# CITY OF ALBUQUERQUE

April 28, 2017

**Re: Palleras Residence  
6331 Camino Alto NW  
Grading and Drainage Plan  
Engineers Stamp Date 4/24/2017 (C10D003C9)**

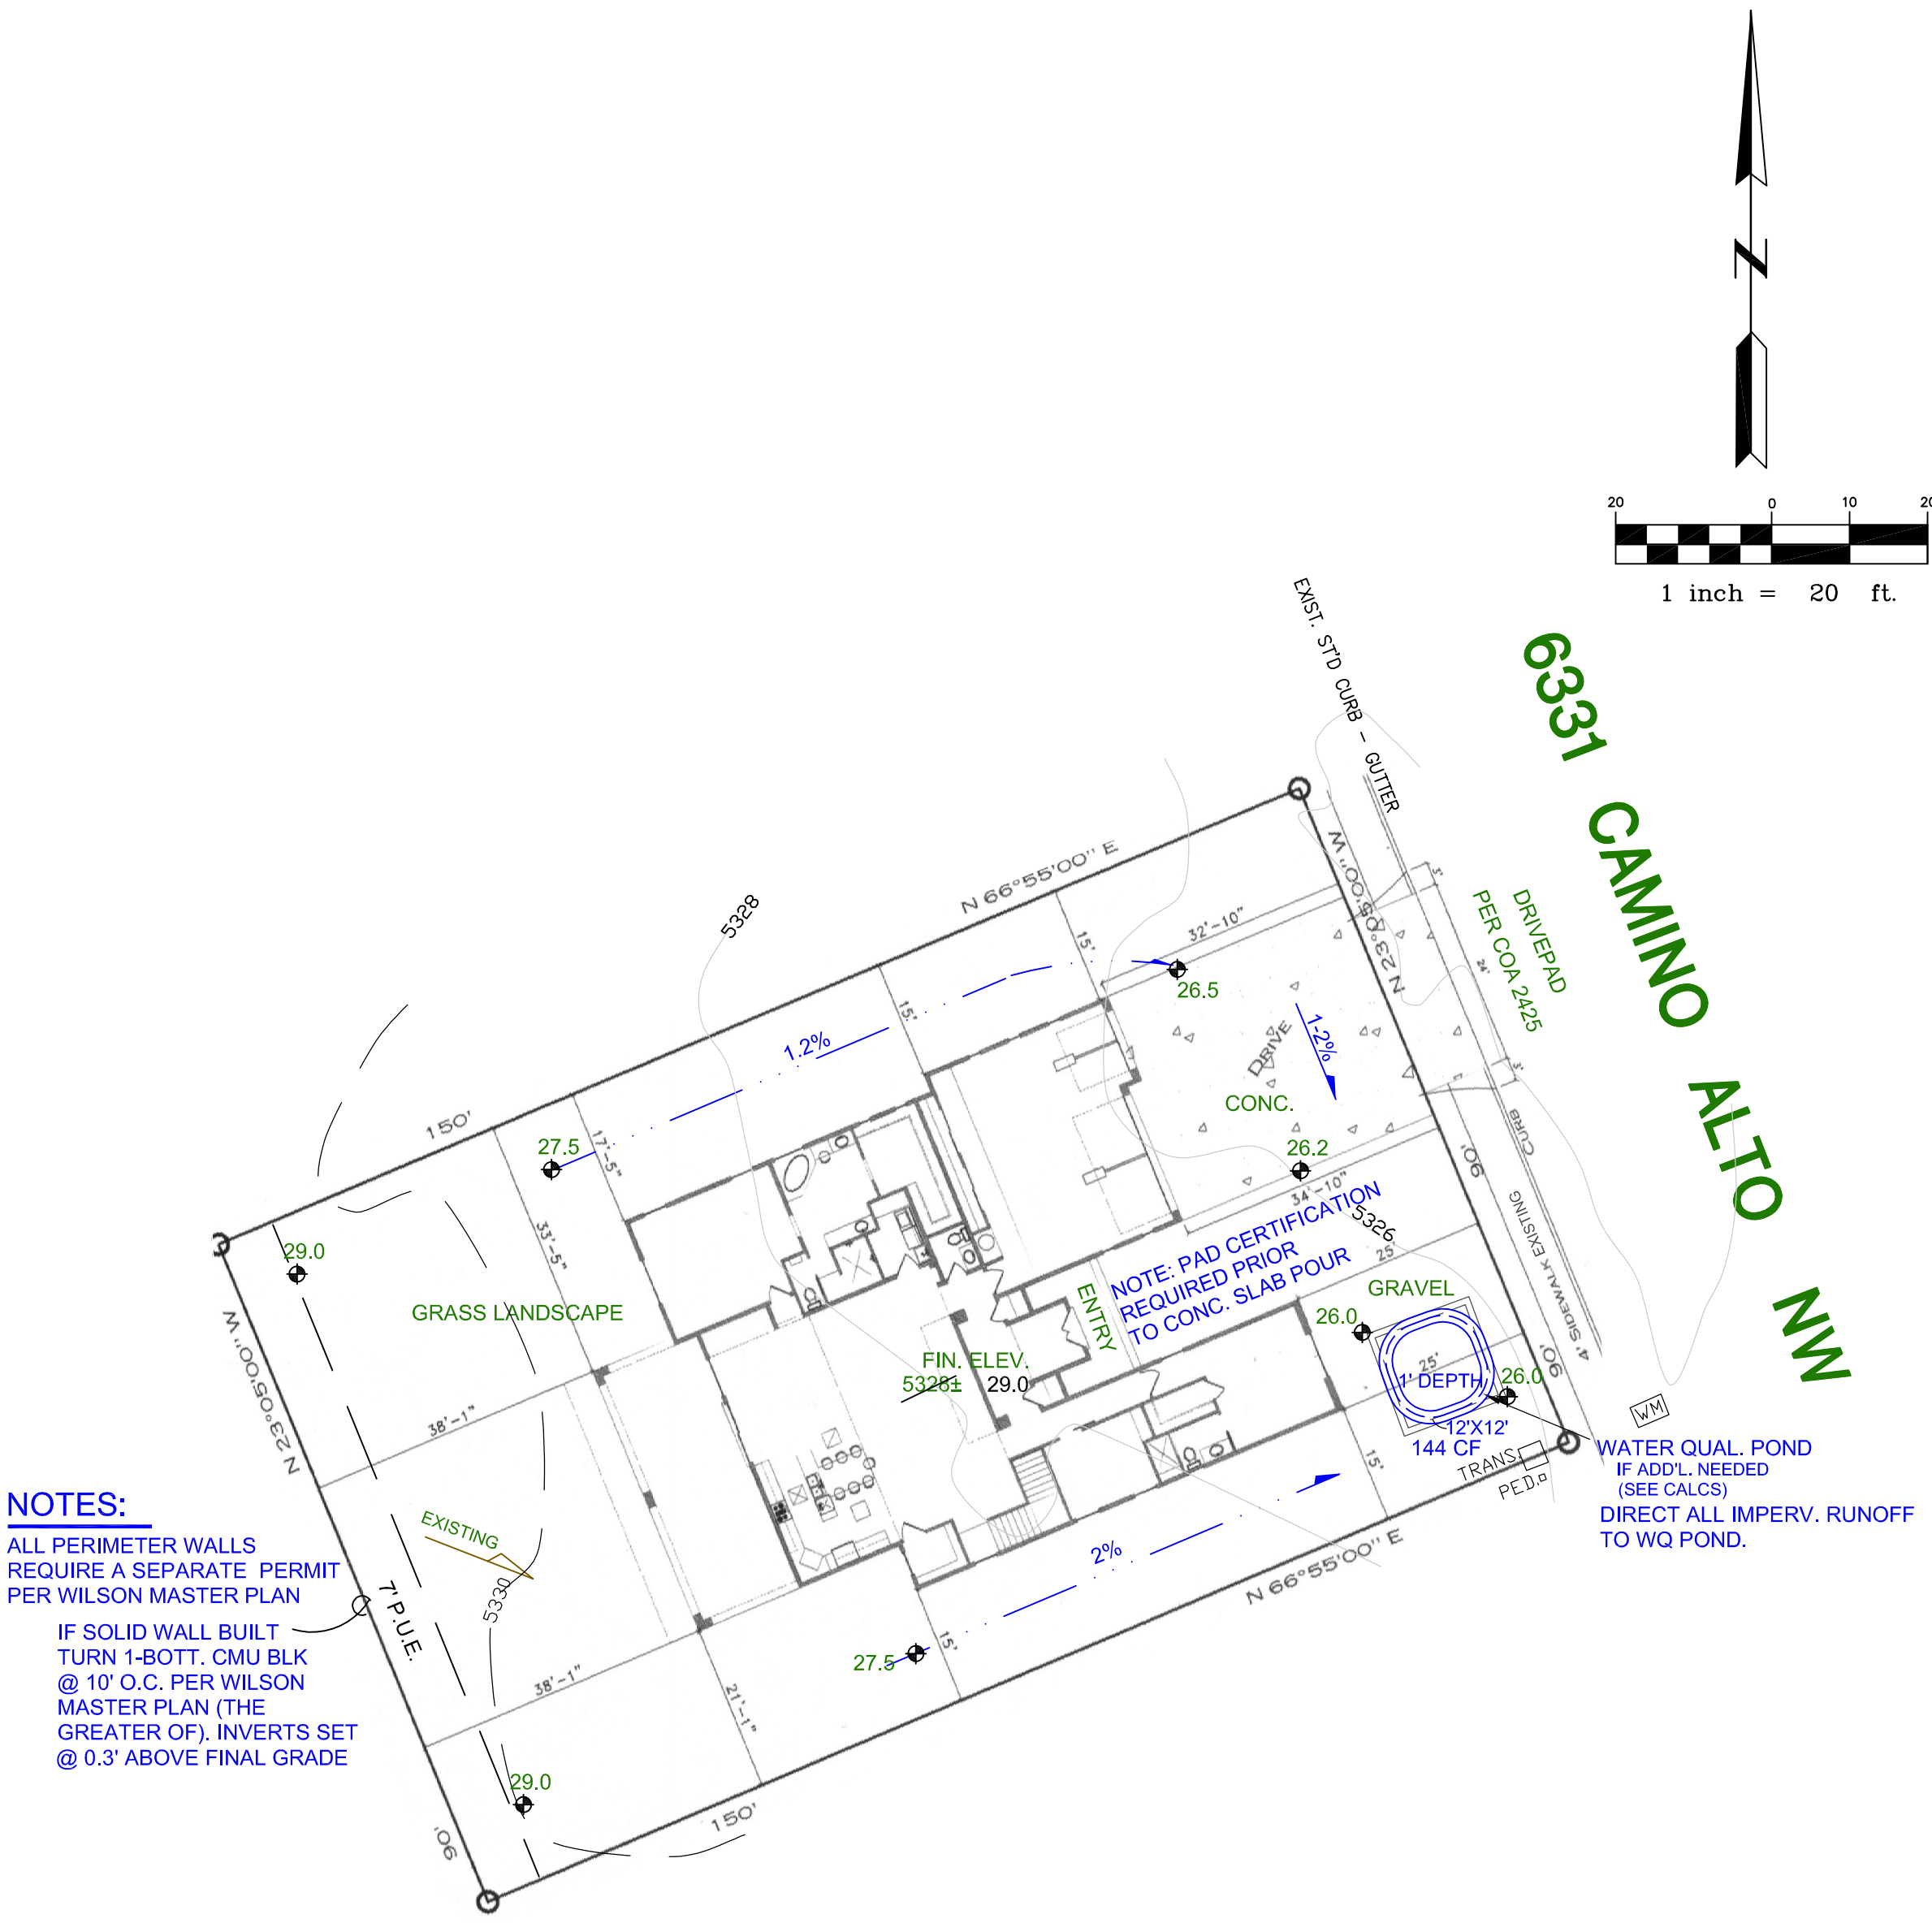
- Show the 7 foot PUE in the back yard.
- Provide how the flows will proceed from NW to SE in the PUE, per approved master drainage plan provided by Wilson and CO.
- Provide a statement that all walls require a separate permit and must follow the approved grading and drainage plan.
- Provide a statement that openings in the rear yard wall must be provided and 3" above the finished grade.
- Provide spot elevations showing how flows will enter water quality pond (WQP). Provide how flows will cross the drive pad and enter the WQP.
- Provide a statement explaining that a pad certification must be provided before the concrete pad is poured.
